DRB Application No.: 09DRB-70213	Project # 1007734
Project Name: NEWTON & SMITH	
Agent: THE SURVEY OFFICE LLC	Phone No.:

DRB Comments

RE: Lots 19 – 24, Newton & Smith Subdivision

**PLAT OF**  
**LOTS 19-A, 20-A, 21-A, 22-A & 23-A**  
**NEWTON AND SMITH SUBDIVISION**  
 PROJECTED SECTION 4, T. 10 N. R. 3 E., N.M.P.M.  
 ALBUQUERQUE GRANT  
 CITY OF ALBUQUERQUE  
 BERNALILLO COUNTY, NEW MEXICO  
 JUNE 2009  
 SHEET 2 OF 2

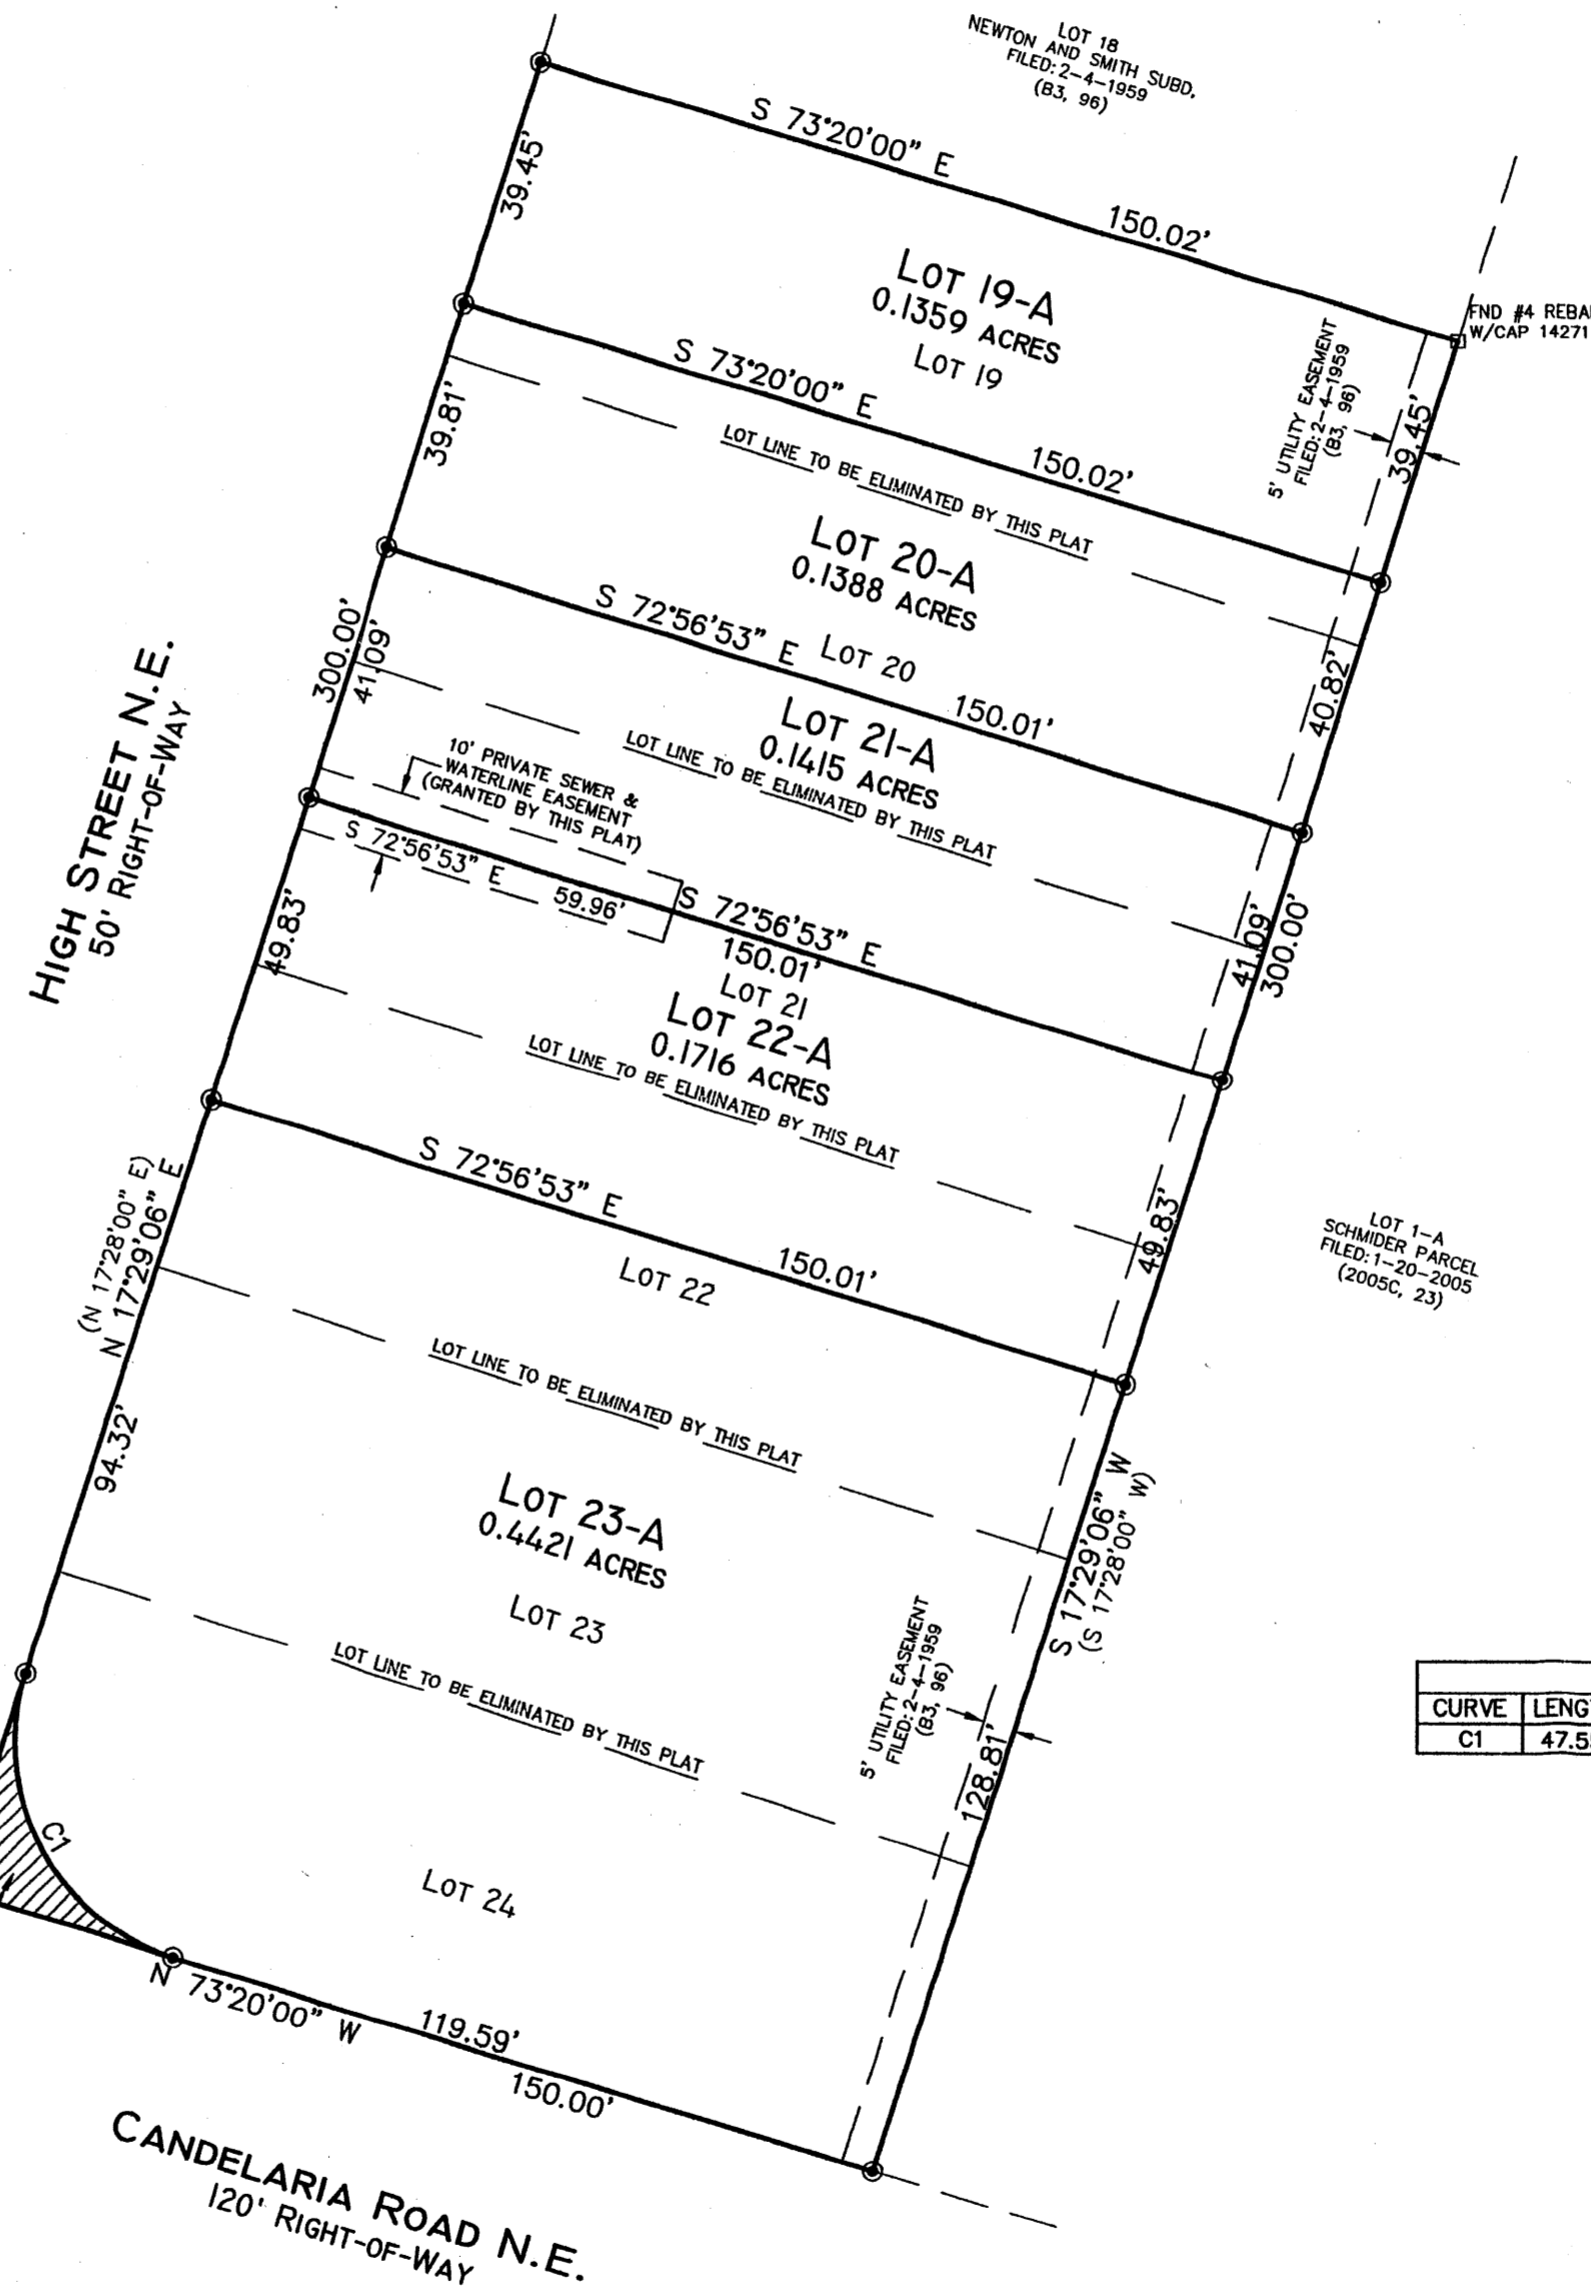
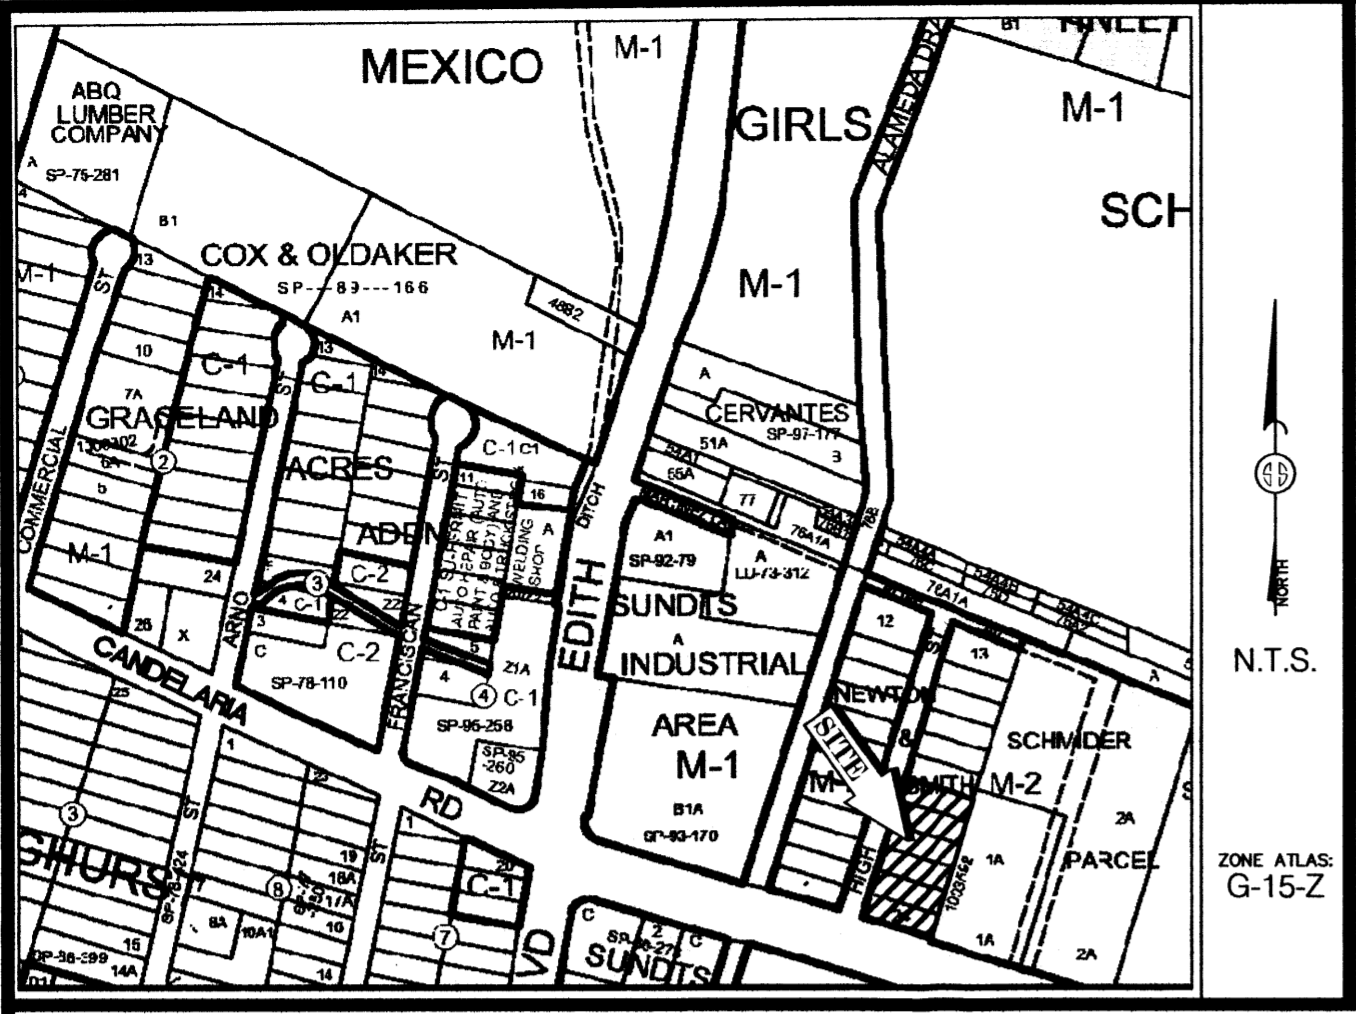
PLANNING (Last to sign): -reciprocal access E'nd

It appears reciprocal cross lot access easement(s) are needed for vehicular maneuvering.

**PLAT OF**  
**LOTS 19-A, 20-A, 21-A, 22-A & 23-A**  
**NEWTON AND SMITH SUBDIVISION**  
 PROJECTED SECTION 4, T. 10 N. R. 3 E., N.M.P.M.  
 ALBUQUERQUE GRANT  
 CITY OF ALBUQUERQUE  
 BERNALILLO COUNTY, NEW MEXICO  
 APRIL 2009  
 SHEET 2 OF 2

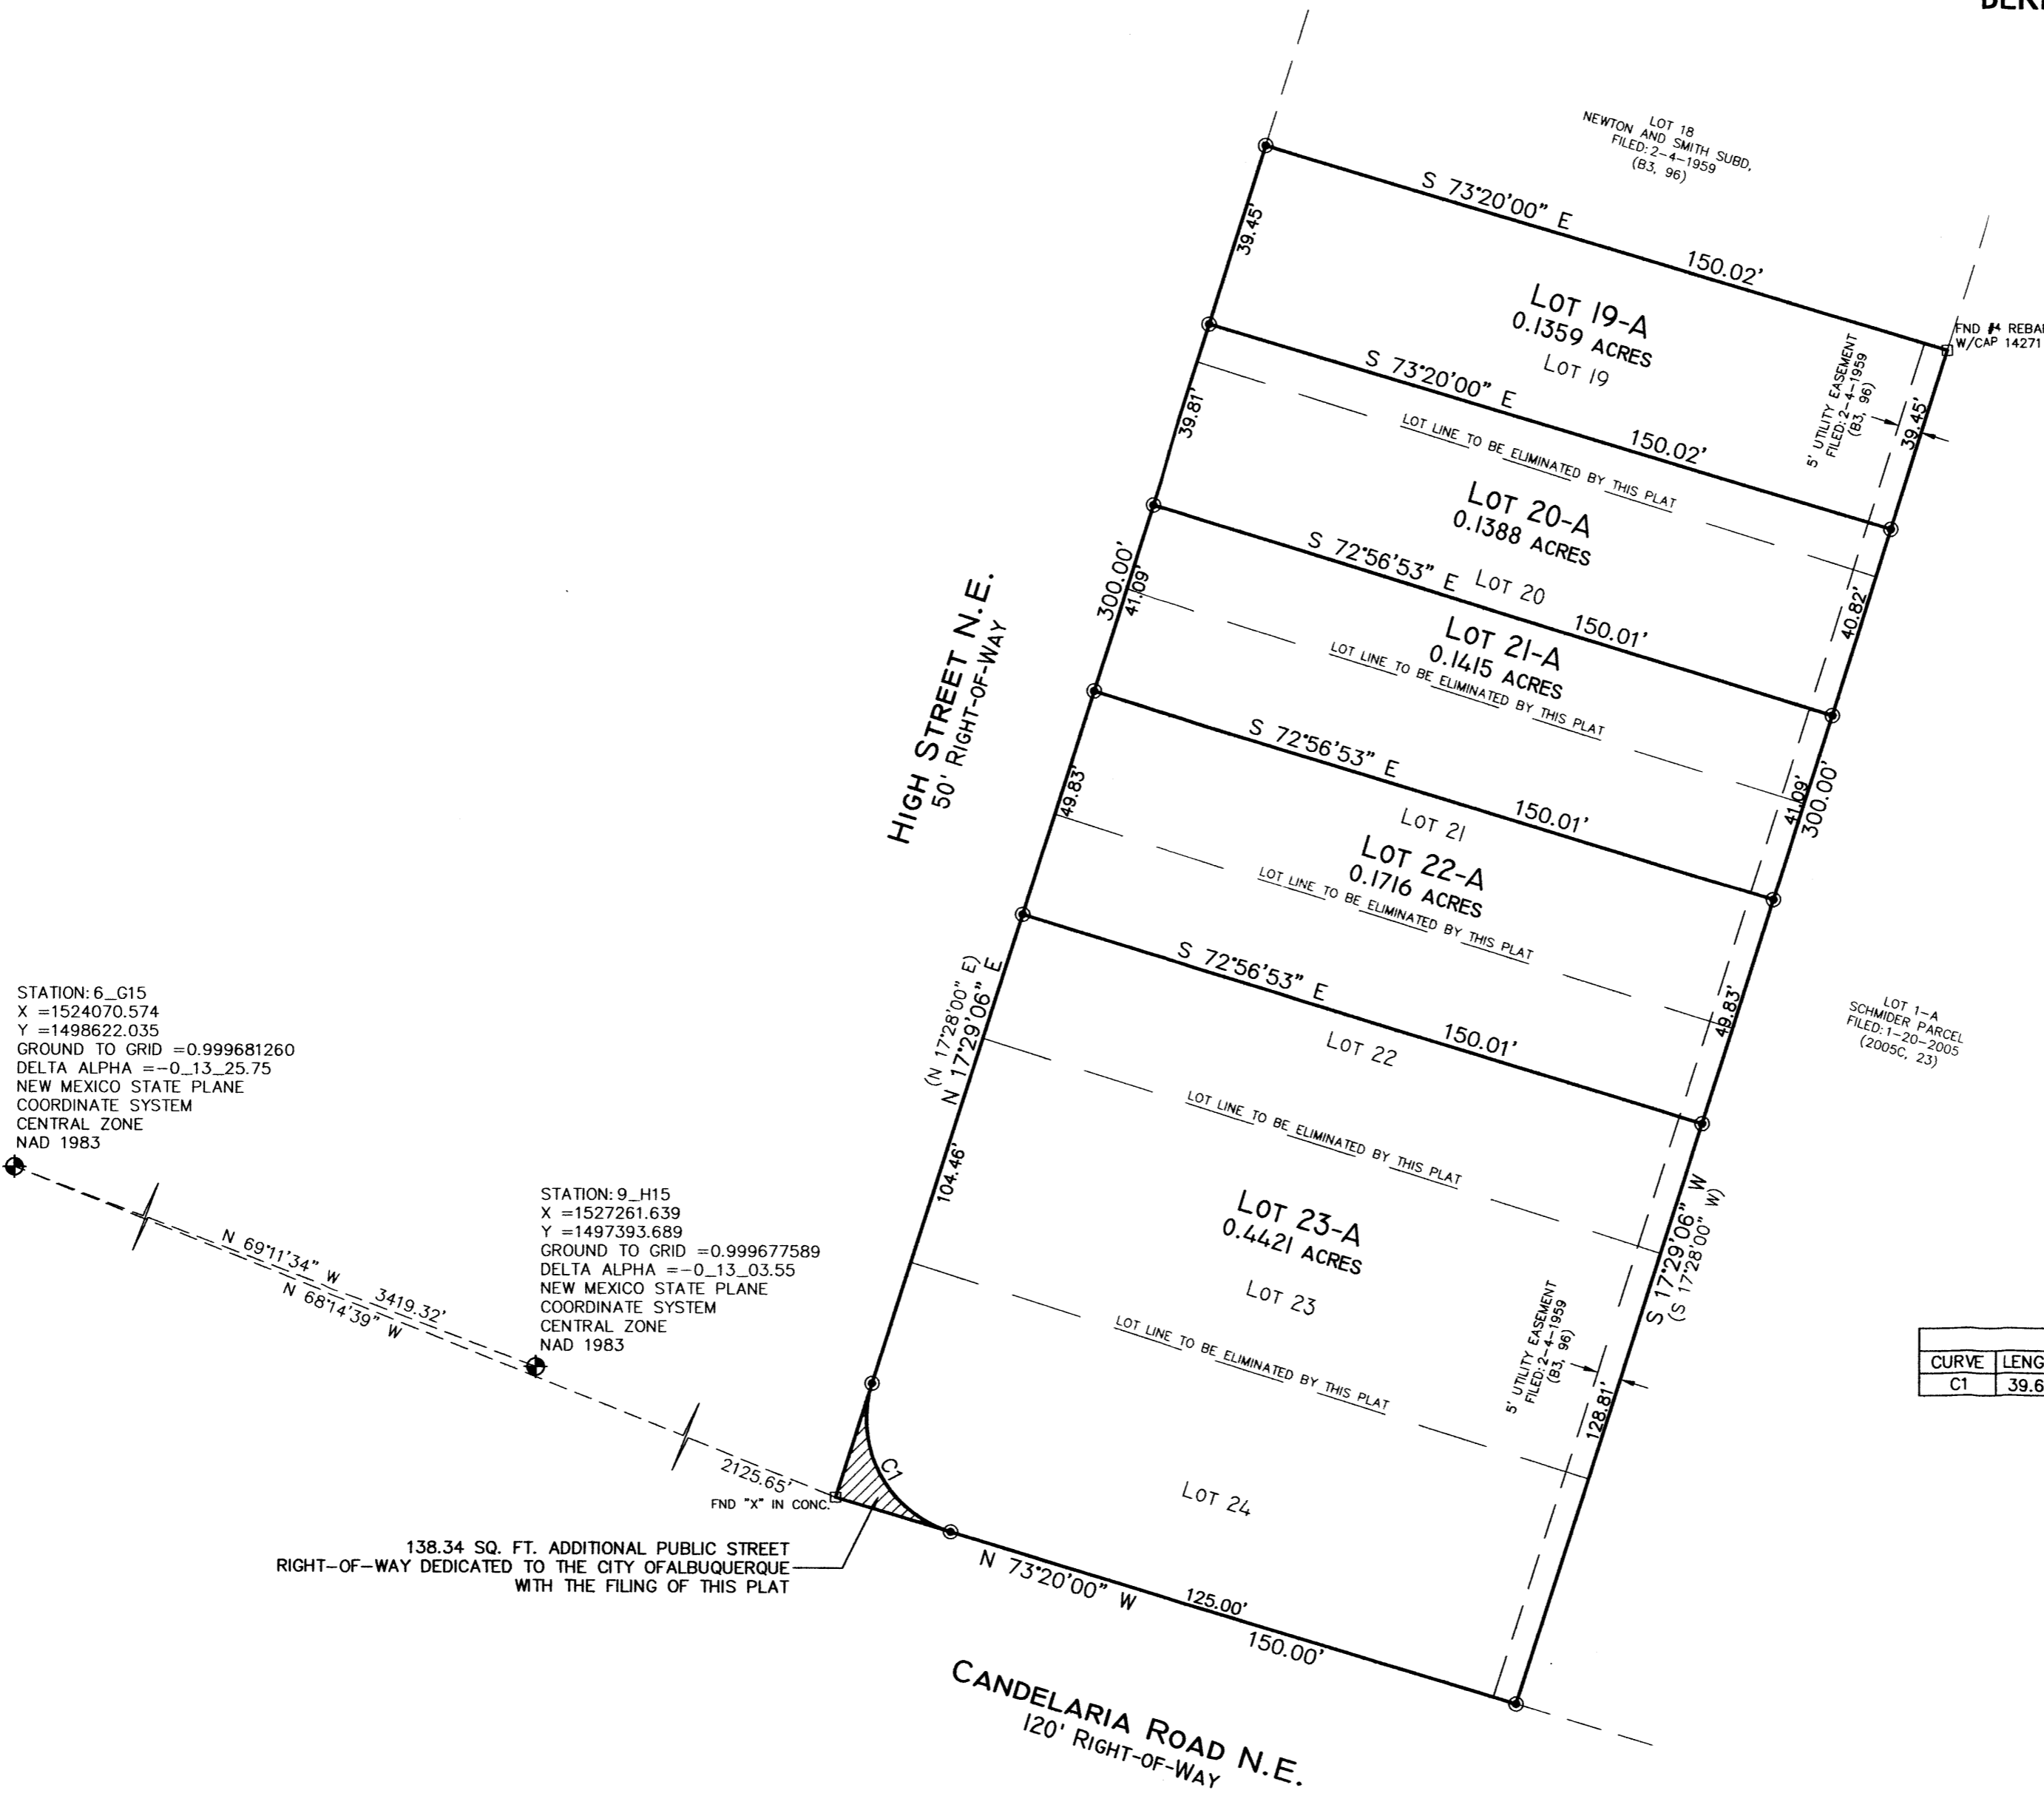
Certification will be needed by an engineer or the City that the buildings and new lot lines are in compliance with the building code (RE: firewalls).

- Certification by an engineer that the replat is in compliance with the building code (Re: firewalls).
- Separate sewer/water accounts for the existing units.
- Sidewalks have been completed and inspected (enclosed documents)
